KITTITAS COUNTY COMMUNITY DEVELOPMENT SERVICES

July 15, 2021

RE: Sweetwater Ranch Conditional Use Application (CU-21-00002)

SITE PLAN

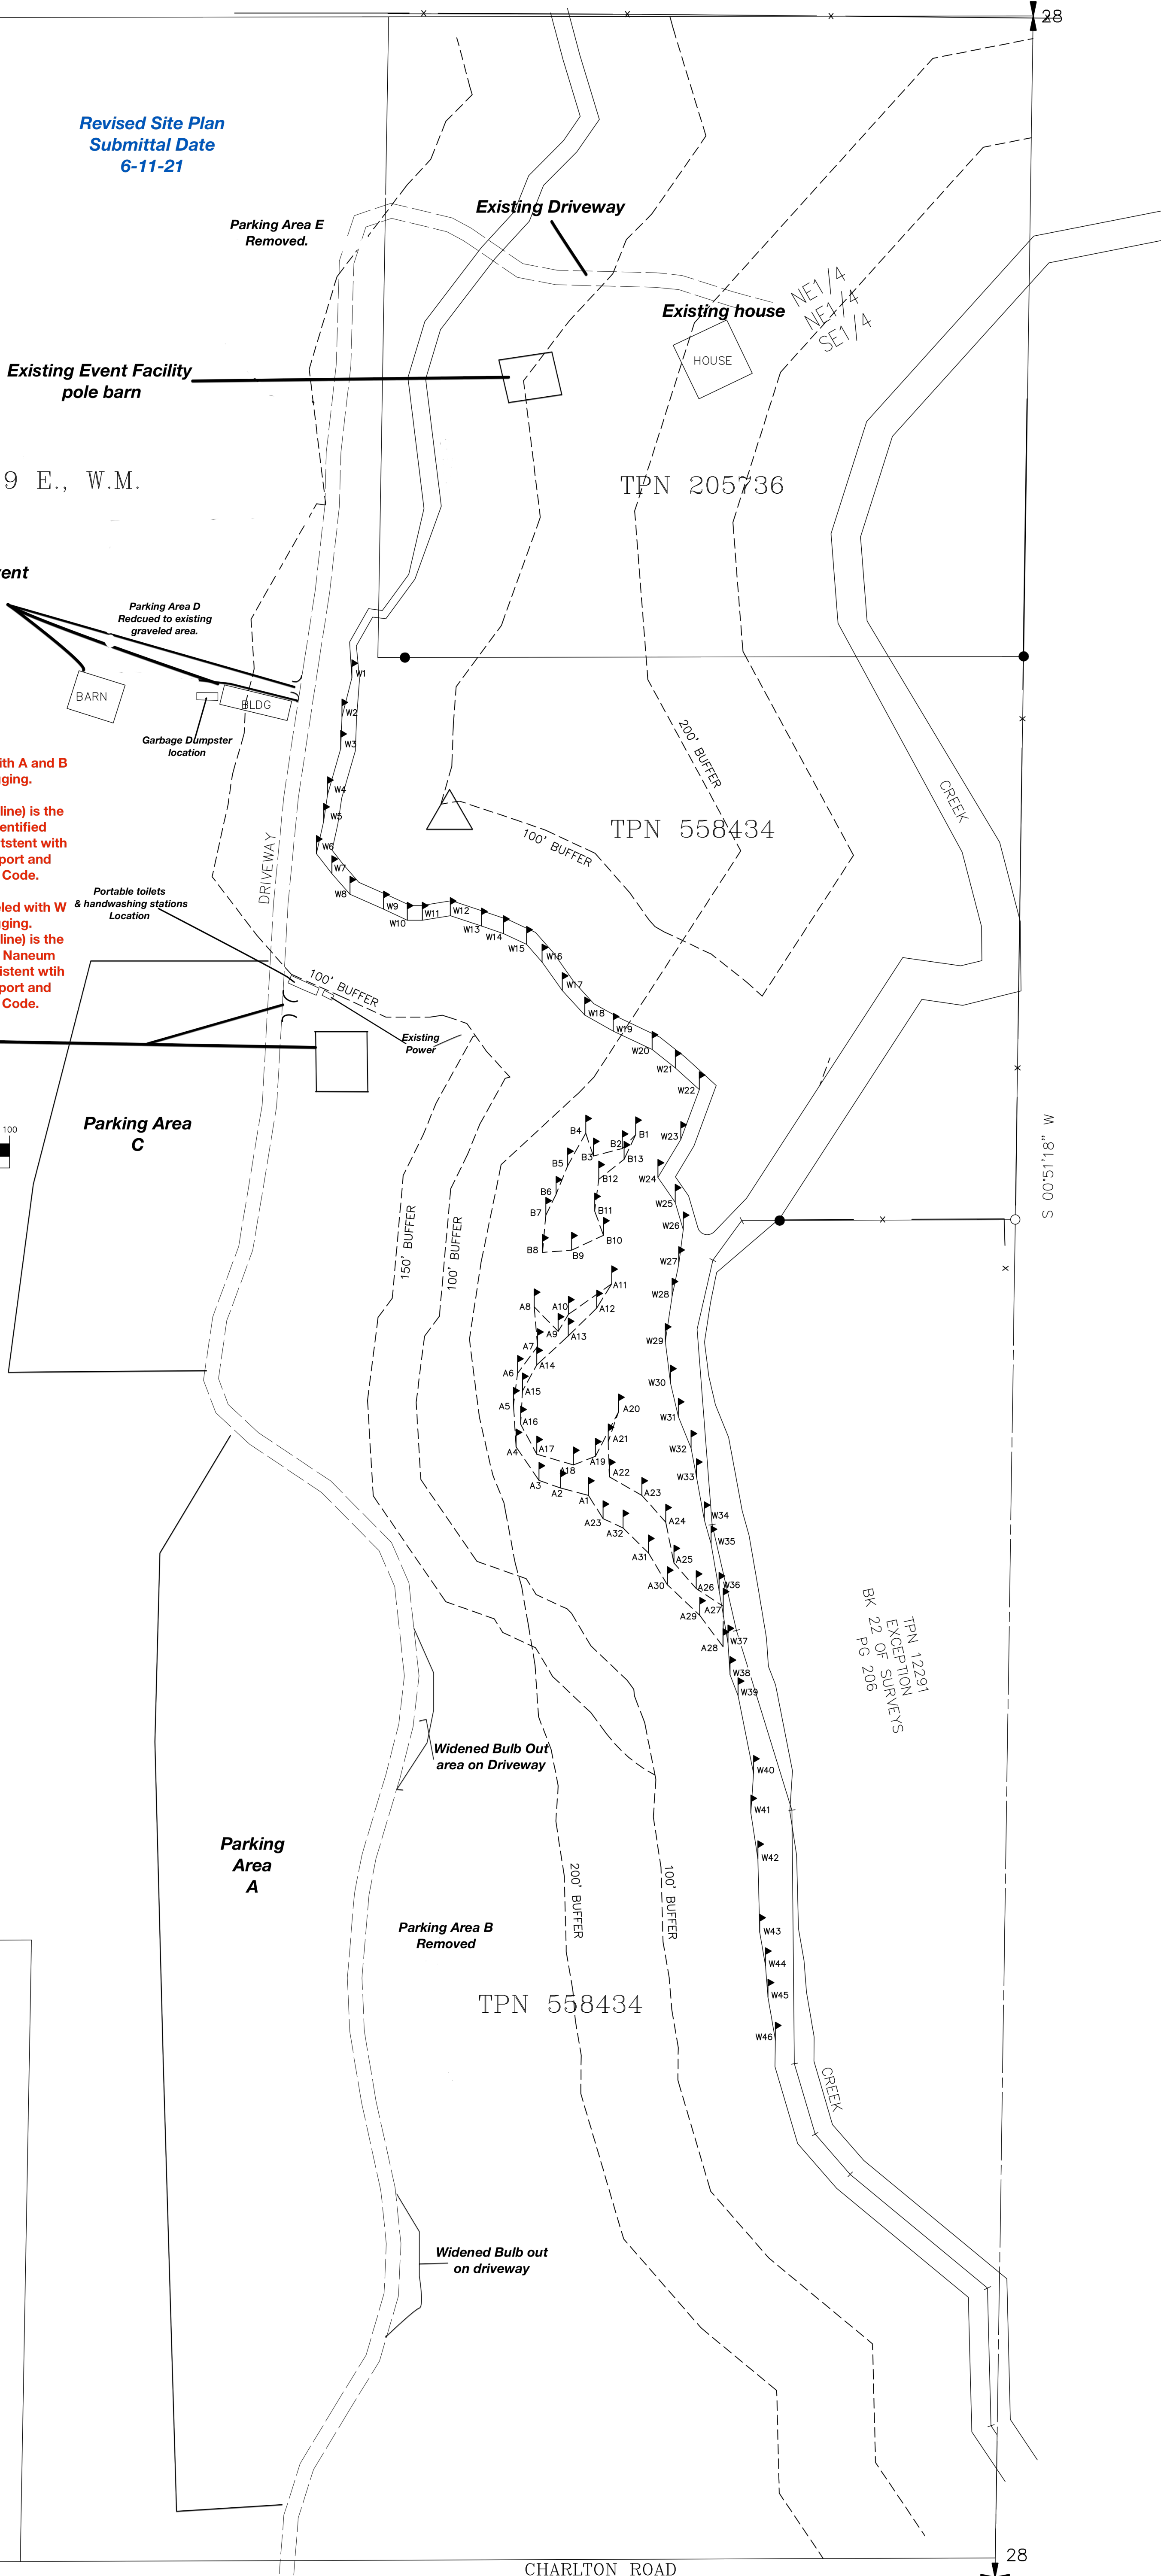
In addition to the request from Lori White for additional information on wetlands located on the southeastern end of the property, Kittitas County Community Development Services agrees with WSDOE's original comments showing that the identified Category II Wetlands A and B of the Sewall Wetland Delineation are considered contiguous wetlands with the associated Shoreline Jurisdiction of the Naneum Creek, therefore they need to be reviewed under the Shoreline Master Program. Category II wetlands have a High Intensity use and development buffer of 200' per KCC17B.05.020G.

There appeared to be a driveway, along with a large yard associated with the event facility building, constructed near the Category II wetlands that may encroach upon these buffers. Mitigation measure may be necessary once additional information has been provided:

- Updated site map showing the wetland buffers associated with Wetland A and B meeting the requirements of KCC 17B Shorelines.
- Additional detail including the event yard and driveway located easternly of the event facility structure located at the center of the property. Any encroachment of the use within this 200' buffer may require mitigation.
